**ANGEL PLACE
LEVEL 8, 123 PITT STREET
SYDNEY NSW 2000**

2 June 2022

SECTION 4.55(1A) MODIFICATION APPLICATION | SSD-10375 MOD 1 PITT STREET NORTH OVER STATION DEVELOPMENT

This updated section 4.55(1A) Modification Application has been prepared on behalf of Pitt Street Developer North Pty Ltd (**the Applicant**) to amend SSD-10375 which applies to the Pitt Street North Over Station Development (**PSN OSD**) Stage 2 SSD-10375 at 252 Pitt Street, Sydney.

Proposed Modification: West Elevation - Ashington Place Lightwell
[SMCSWSPS-FOS-OSN-AT-DWG-960005 Rev A]

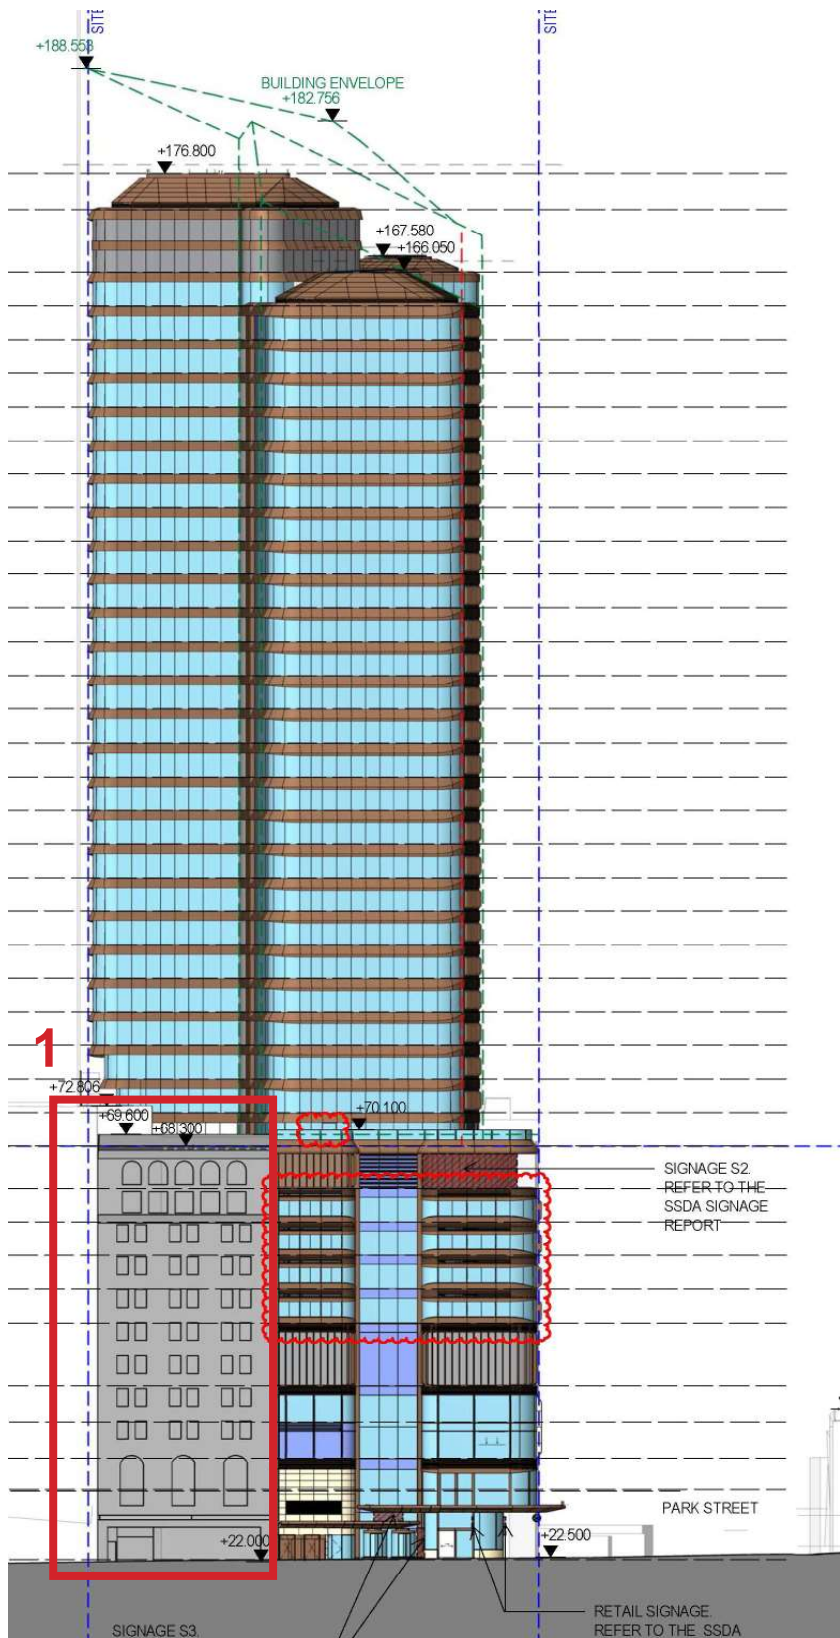
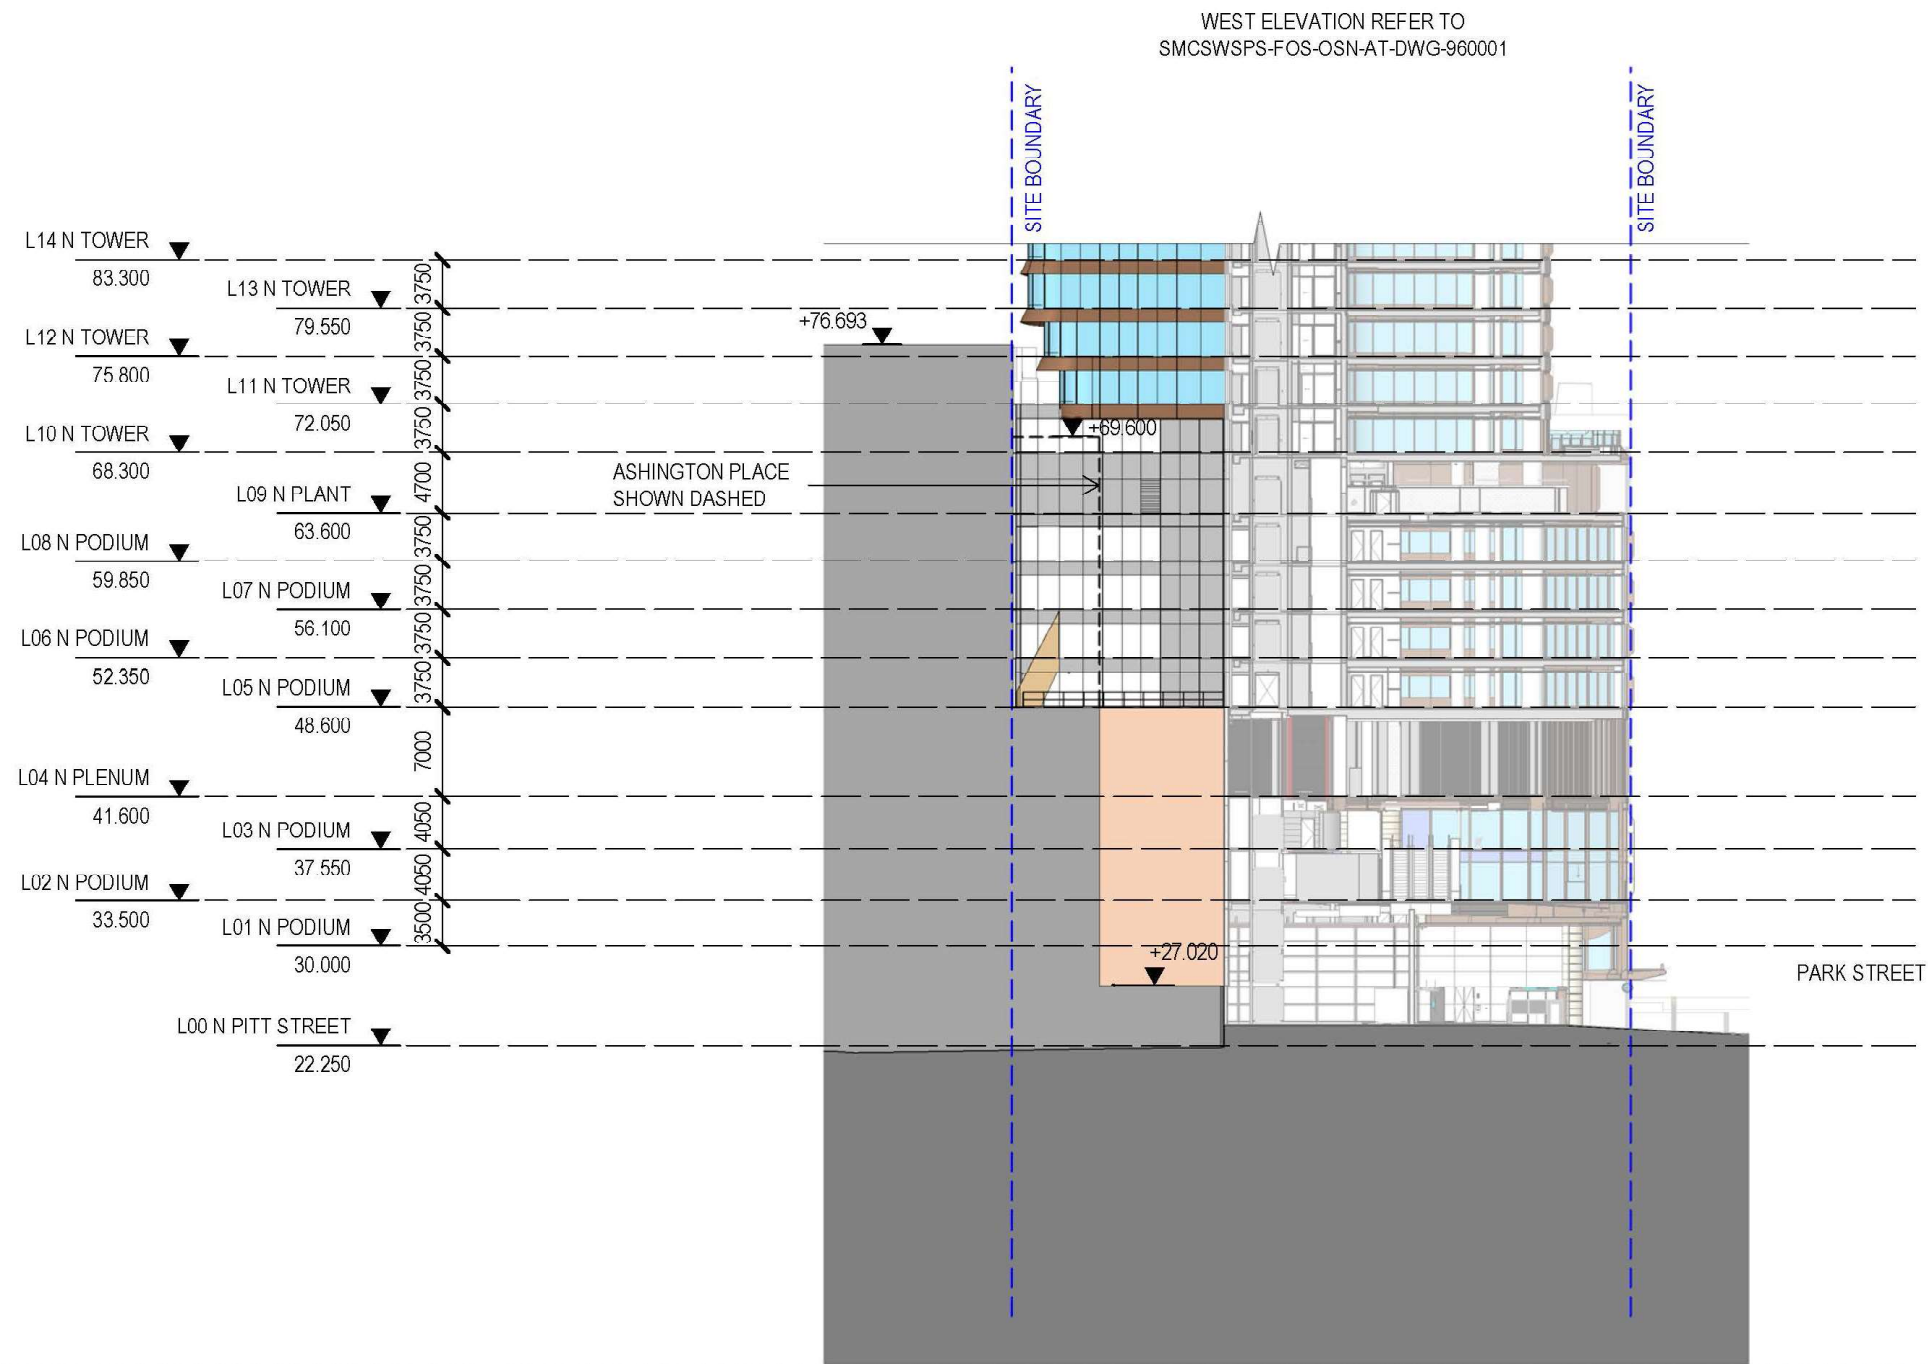
The north western façade of the OSD podium was obscured in the approved General Arrangement Elevation West Elevation - Pitt Street Plan (drawing SMCSWSPS-FOS-OSN-AT-DWG-960001) as illustrated in **Figure 10**.

As part of this modification application it is proposed to include an additional plan General Arrangement Elevation North Western Façade (North – South Section) (SMCSWSPS-COX-OSN-AT-DWG-960005) with details of the secondary western façade as illustrated in **Figure 11**.

1.3 Modification to Terrace Openings

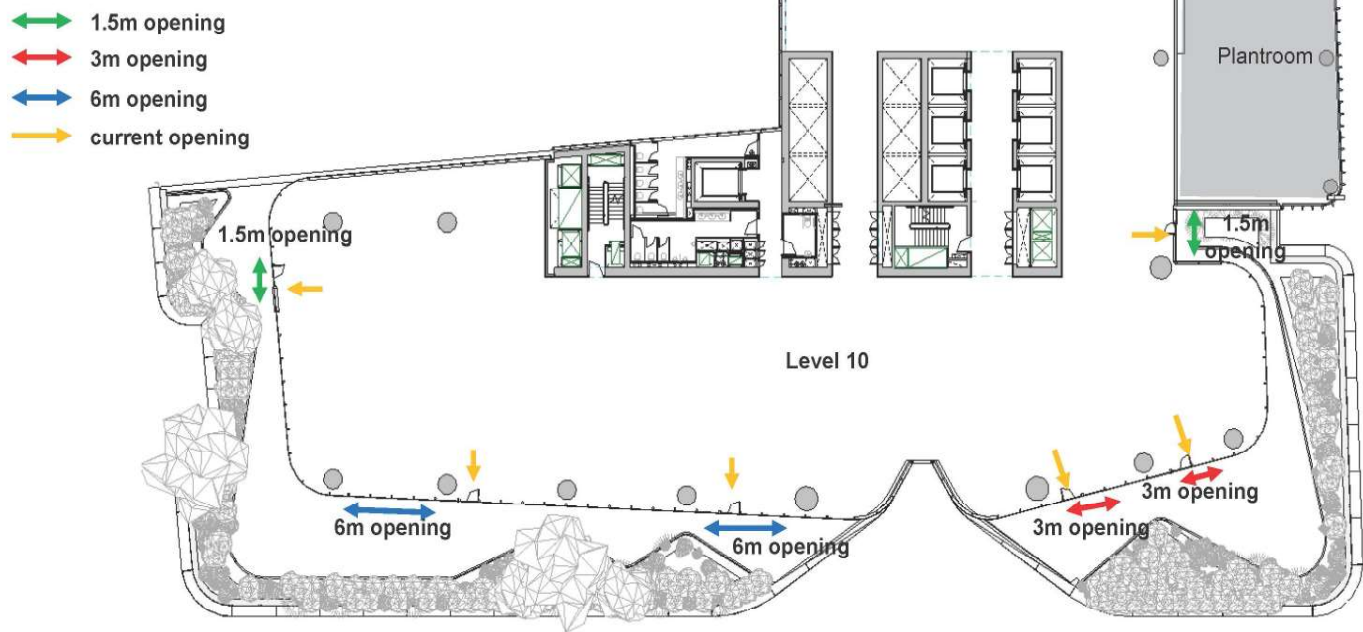
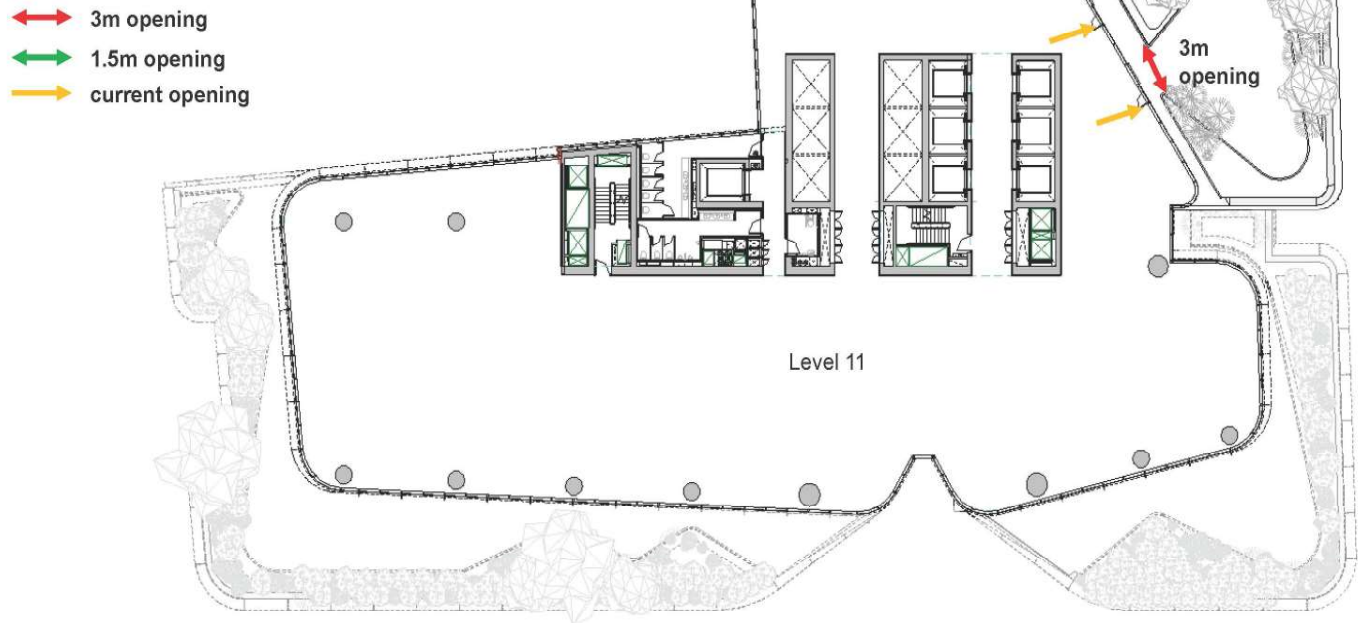
It is proposed to modify the Level 10 and Level 11 terrace door openings from single width swing doors to sliding doors of various widths as illustrated in **Figure 12** and **Figure 13**.

Proposed Modification: Modification to L10 Transom

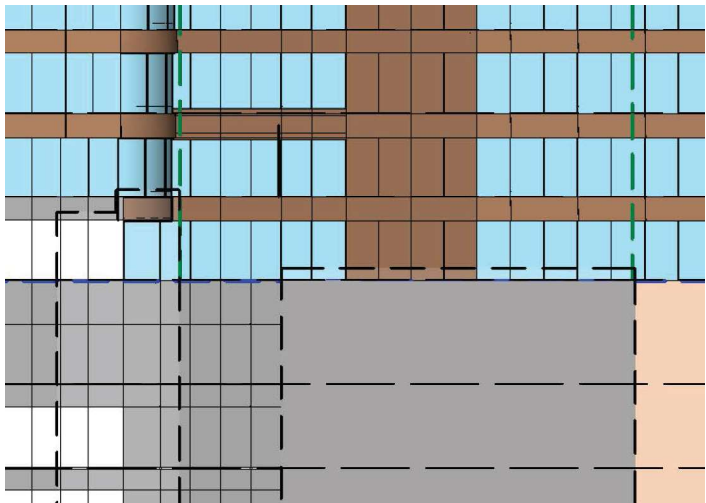
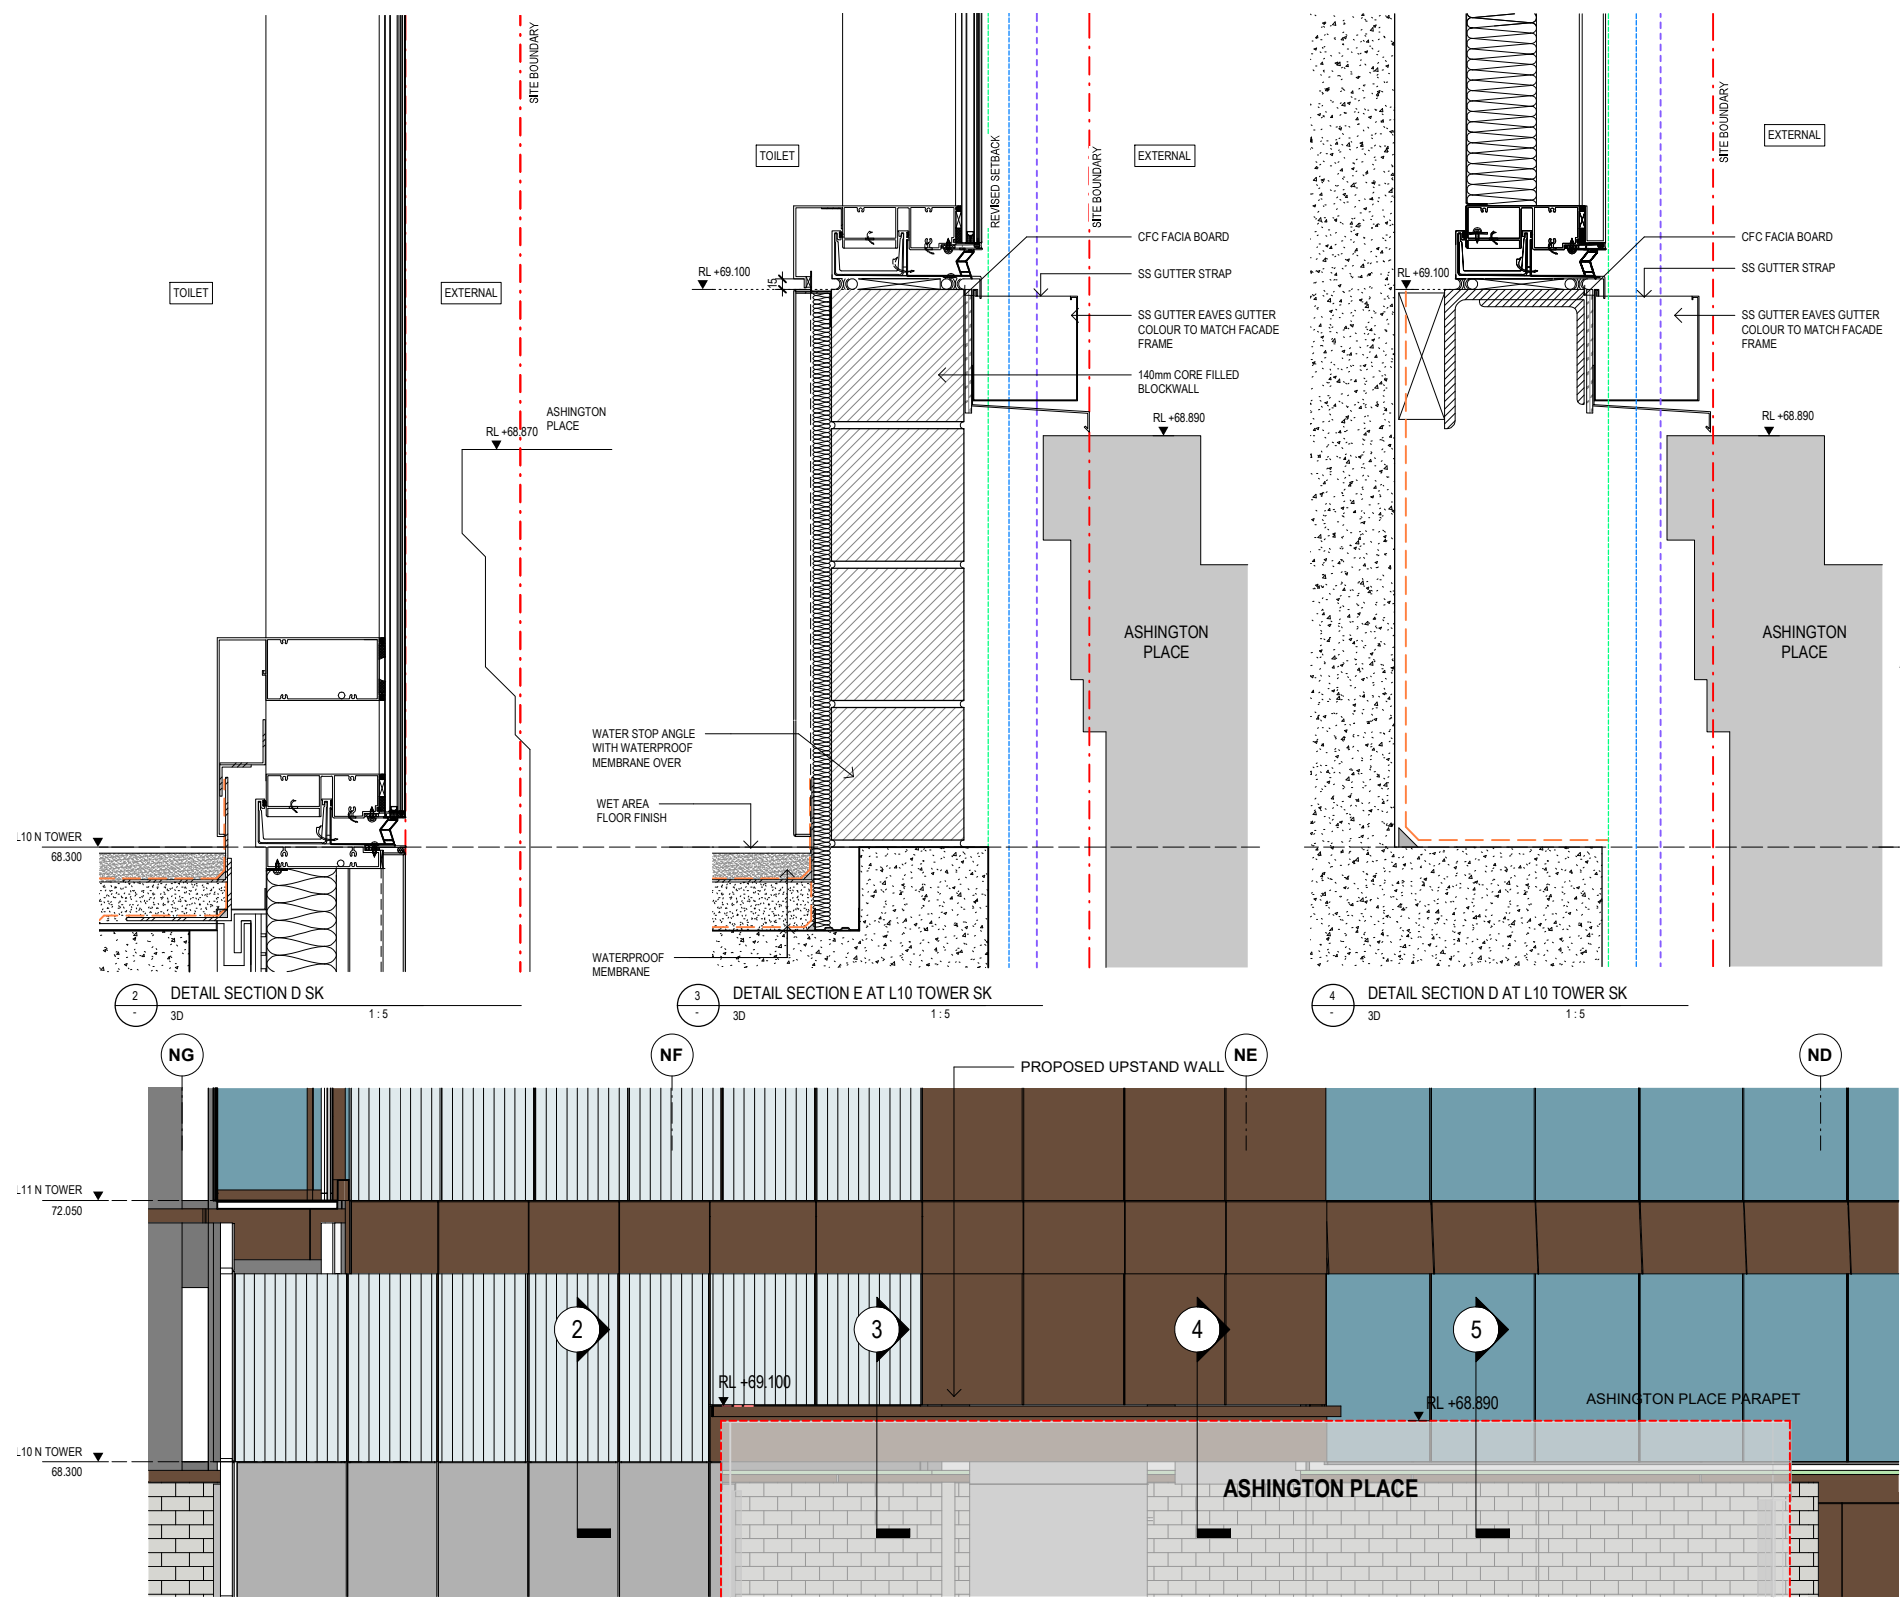
It is proposed to raise the Level 10 horizontal transom adjacent to Ashington Place to allow for adequate waterproofing structures between the two buildings. Currently the approved SSD DA plans show a full height curtain wall window in this location adjacent to the unfinished boundary wall of Ashington Place as illustrated in Picture 1 of **Figure 14**.

As illustrated Picture 2 of **Figure 14** and in **Figure 15** the modification proposes a box gutter at the height of the adjacent building structure with curtain wall window above and block wall infill under the transom.

The proposed modification will not result in any fixture being secured to Ashington Place which protrudes into the PSN site. Sealant will be applied to prevent water seeping in between the PSN OSD and Ashington Place Structures.
